From: Mau, Russell E (DOH) <Russell.Mau@DOH.WA.GOV>
Sent: Tuesday, March 4, 2025 8:49 AM
To: Ellie Myers
Cc: Melissa Schumaier
Subject: RE: AU-25-00003 Merten- Notice of Application

The Department of Health (DOH) Office of Drinking Water (ODW) has reviewed the application generating the following comment:

Subject: AU-25-00003 Merten- Notice of Application

Drawing file: AU-25-00003 Merten / AU-25-00003 Merten - Application - Site Plan.pdf

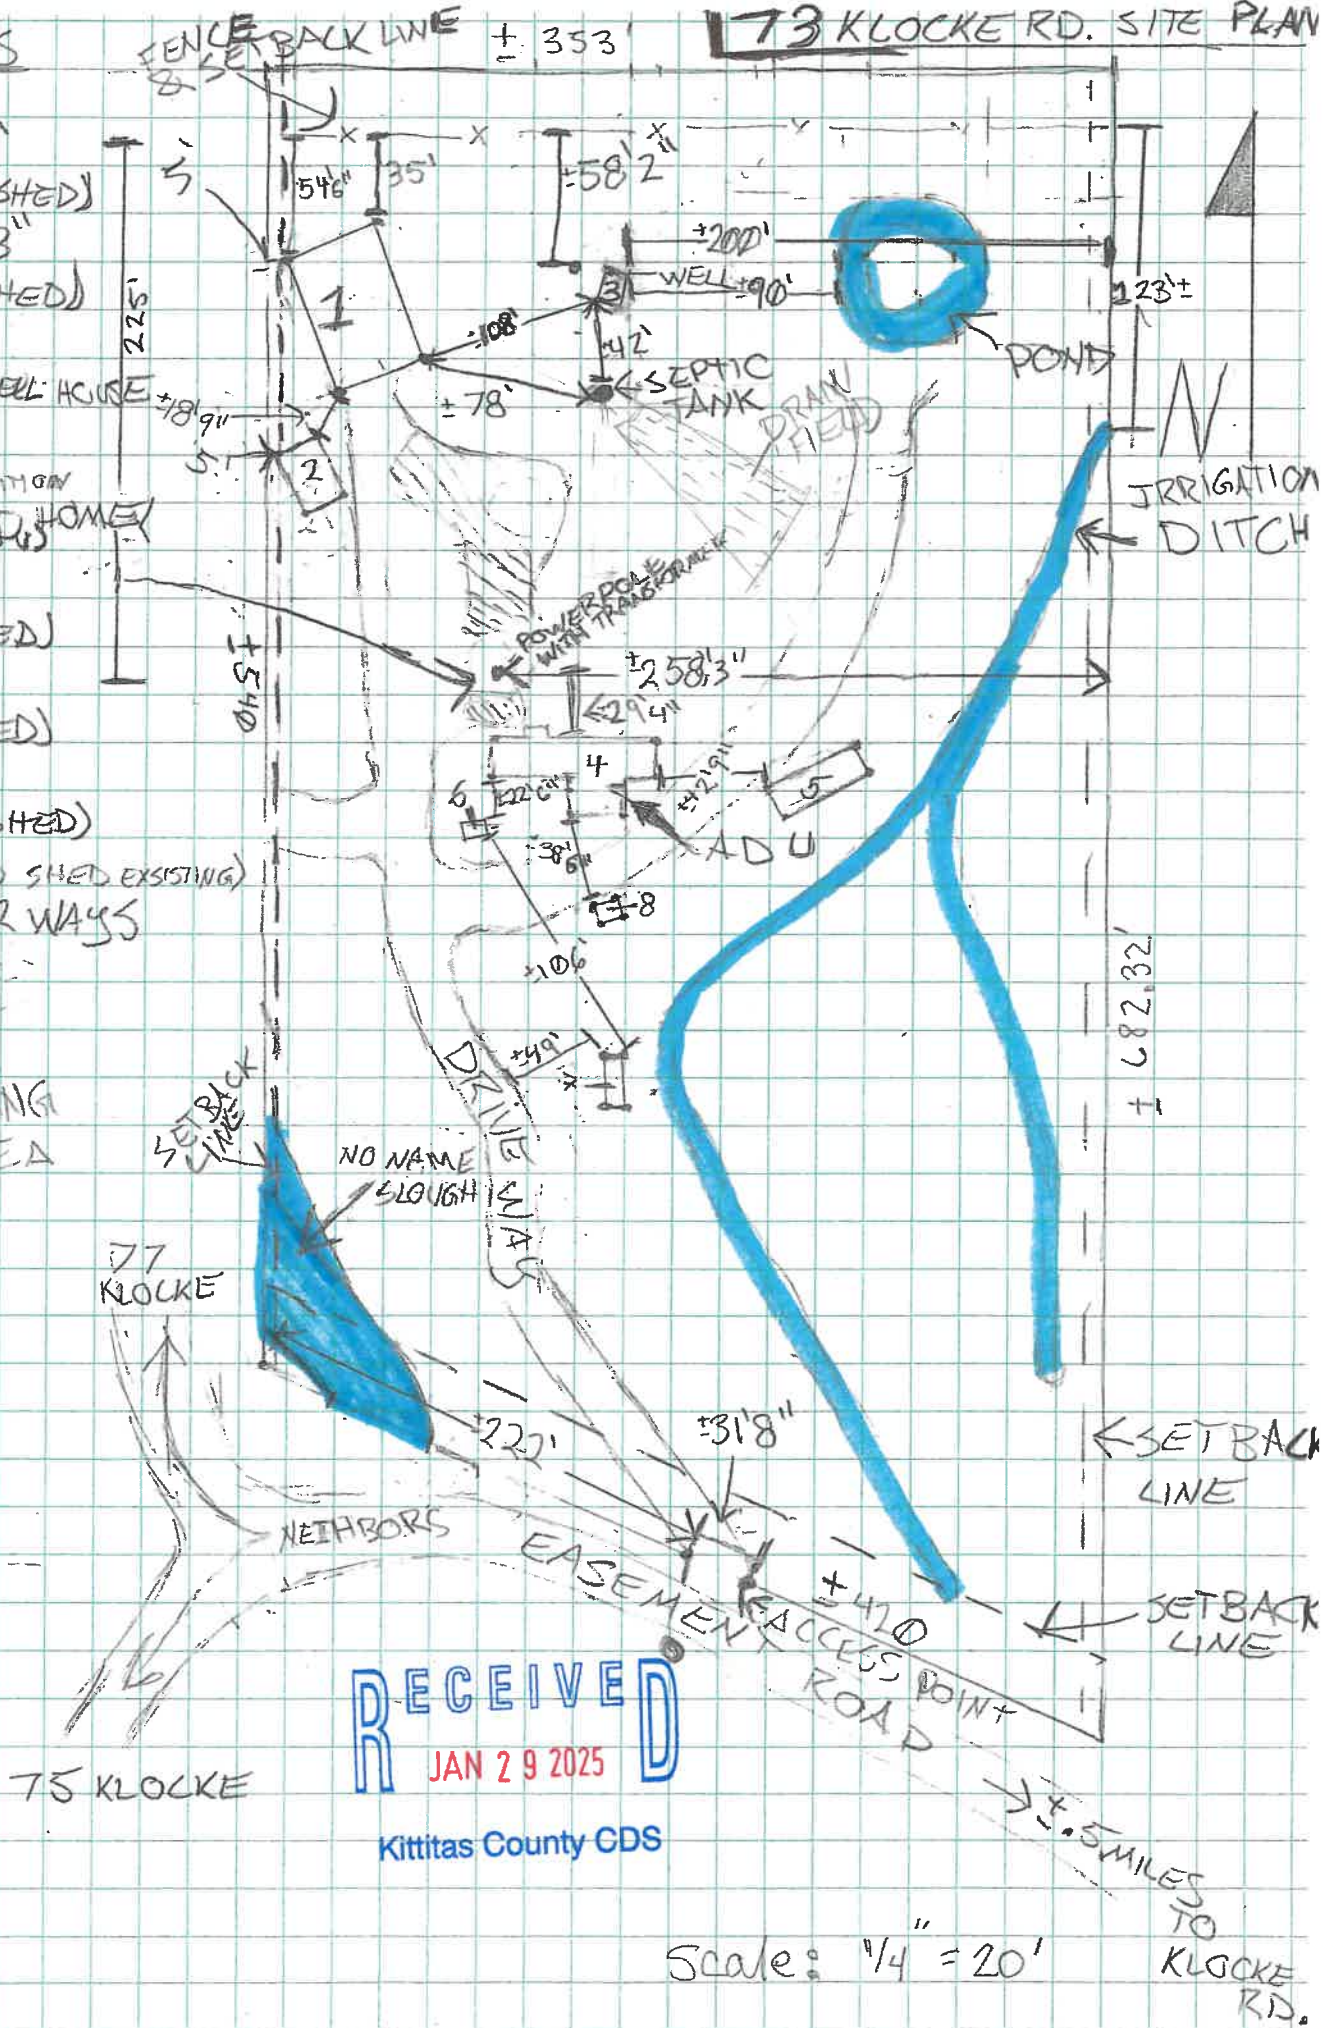
1. With the second dwelling unit, the private well will serve two homes – by definition, this is a “shared” well and does not meet the definition of a public water system.
2. If a third dwelling unit is considered or served by this same well, then it would meet the definition of a Group B public water system under the exclusive authority of Kittitas County Health.
